7 May 2012

**CORMORANT ROAD / TOURLE STREET (MR108) AND INDUSTRIAL DRIVE (MR316):
EXHIBITION OF ENVIRONMENTAL ASSESSMENT FOR PORT WARATAH COAL SERVICES
TERMINAL 4 (MP 10_0215)**

Dave Young
Manager, Land Use Development
Development North
Infrastructure Development

Future site access plan showing proposed intersection improvements

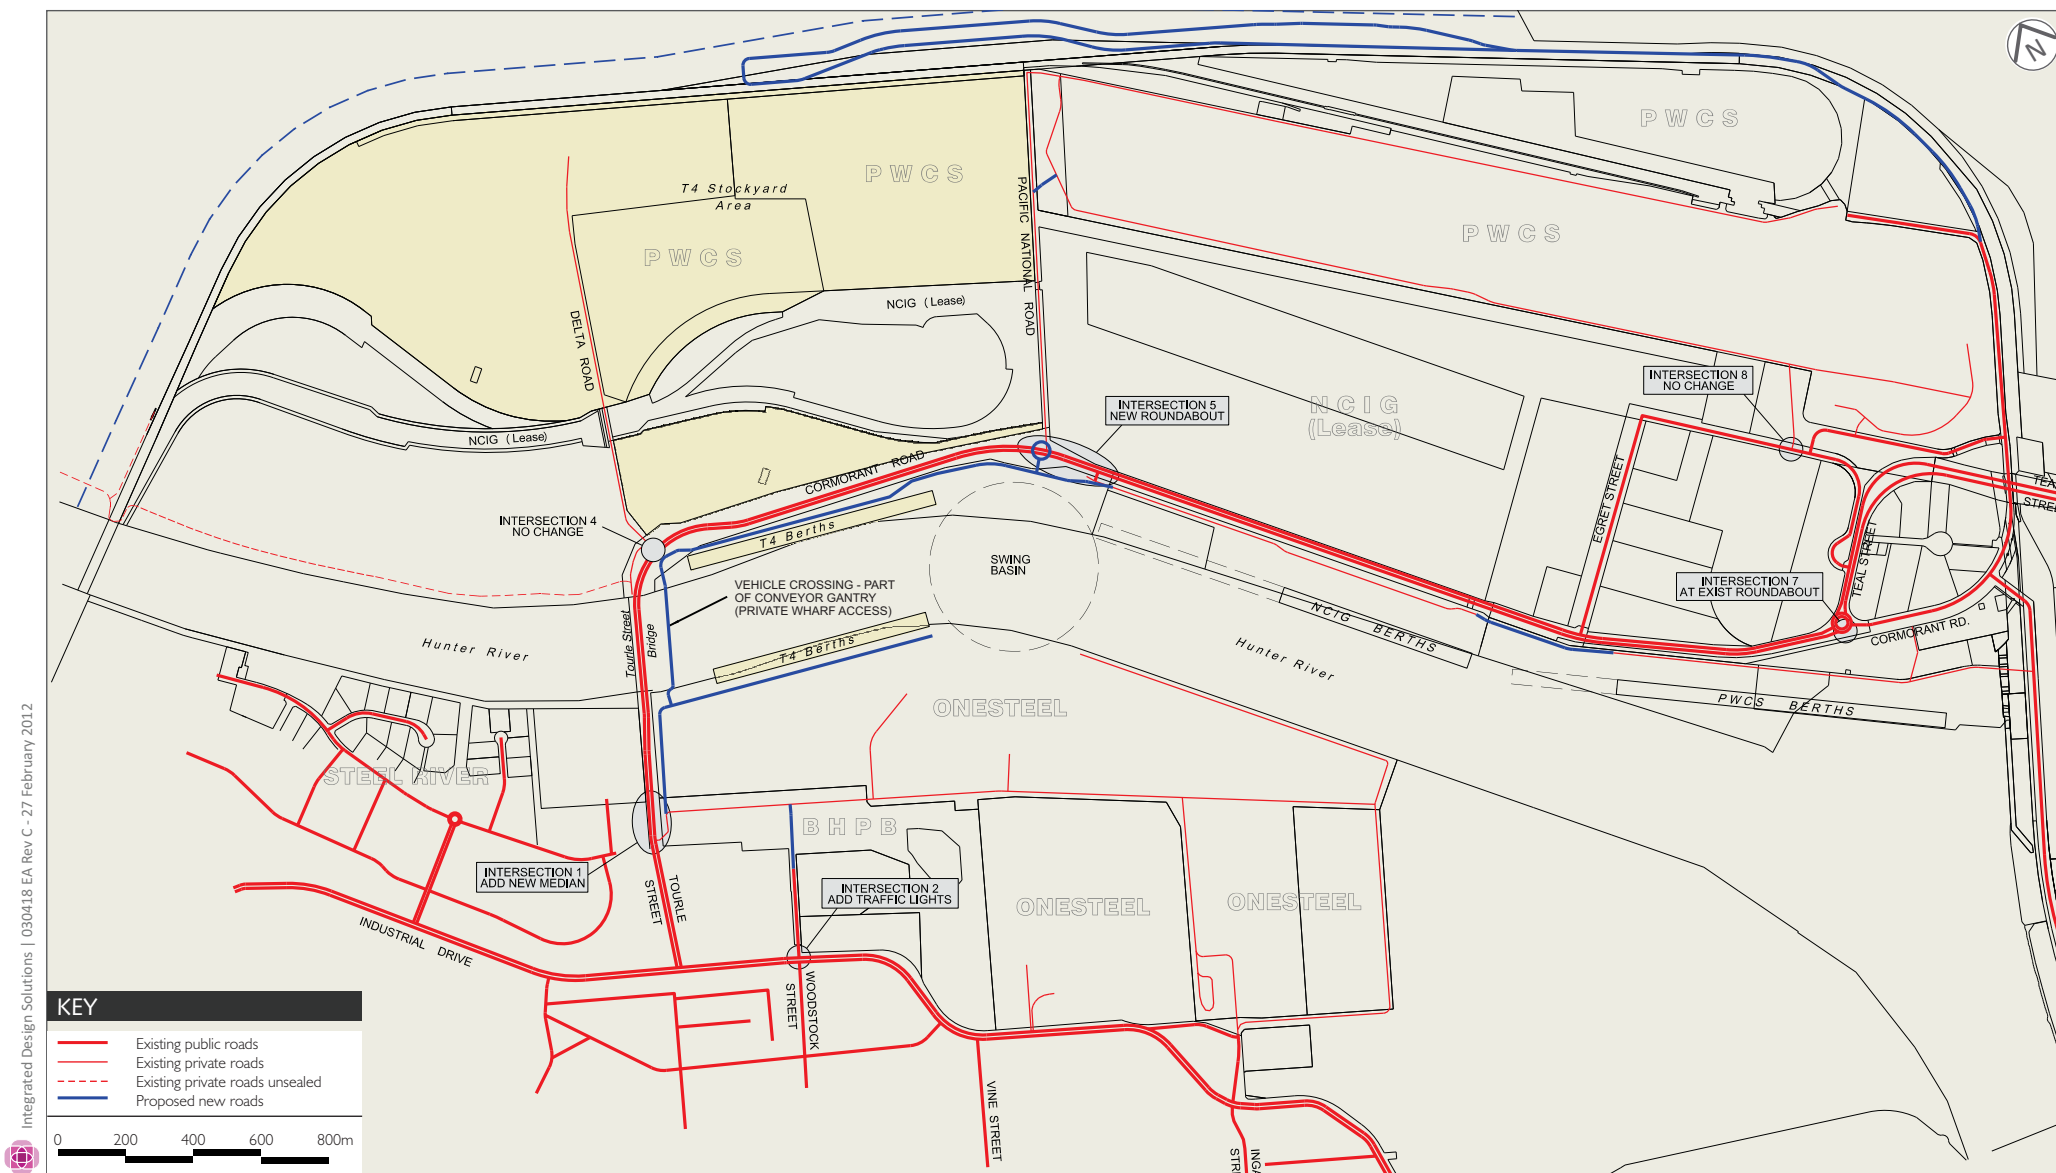
1. Cormorant Road / Pacific National Access Road / Terminal 4 Eastern Access Road

- Prior to the issuing of a construction certificate for Stage 1 works the developer shall upgrade the existing Cormorant Road / Pacific National Access Road intersection. The intersection shall be designed and constructed in accordance with the Austroads *Guide to Road Design 2009* (with RMS supplements) and the RTA *Traffic Signal Design 2008* (where TCS intersection is agreed by RMS to be the best option) to the satisfaction of RMS including, but not limited to, the following works:
 - Upgrading the intersection to a four leg traffic signal controlled intersection or alternatively a four leg circulating roundabout.
 - The required lane configuration, types and lengths shall be determined by RMS subject to a review of the requested revised traffic analysis to be prepared to the satisfaction of RMS in accordance with the RTA's *Guide to Traffic Generating Developments*.

- Signalised pedestrian crossings shall be provided on all legs.
- Street lighting shall be provided to Australian Standards.
- The intersection shall be designed and constructed to accommodate on-road cyclists unless specified otherwise by RMS. If cyclists cannot be accommodated on road due to site constraints, and subject to the agreement of RMS, adequate provision shall be made off-road.
- This work shall be designed and constructed to suit the future duplication of Cormorant Road.

Note: Further traffic analysis is required for the traffic control signals option at the Cormorant Road / Pacific National Access Rd / T4 Access Road intersection.
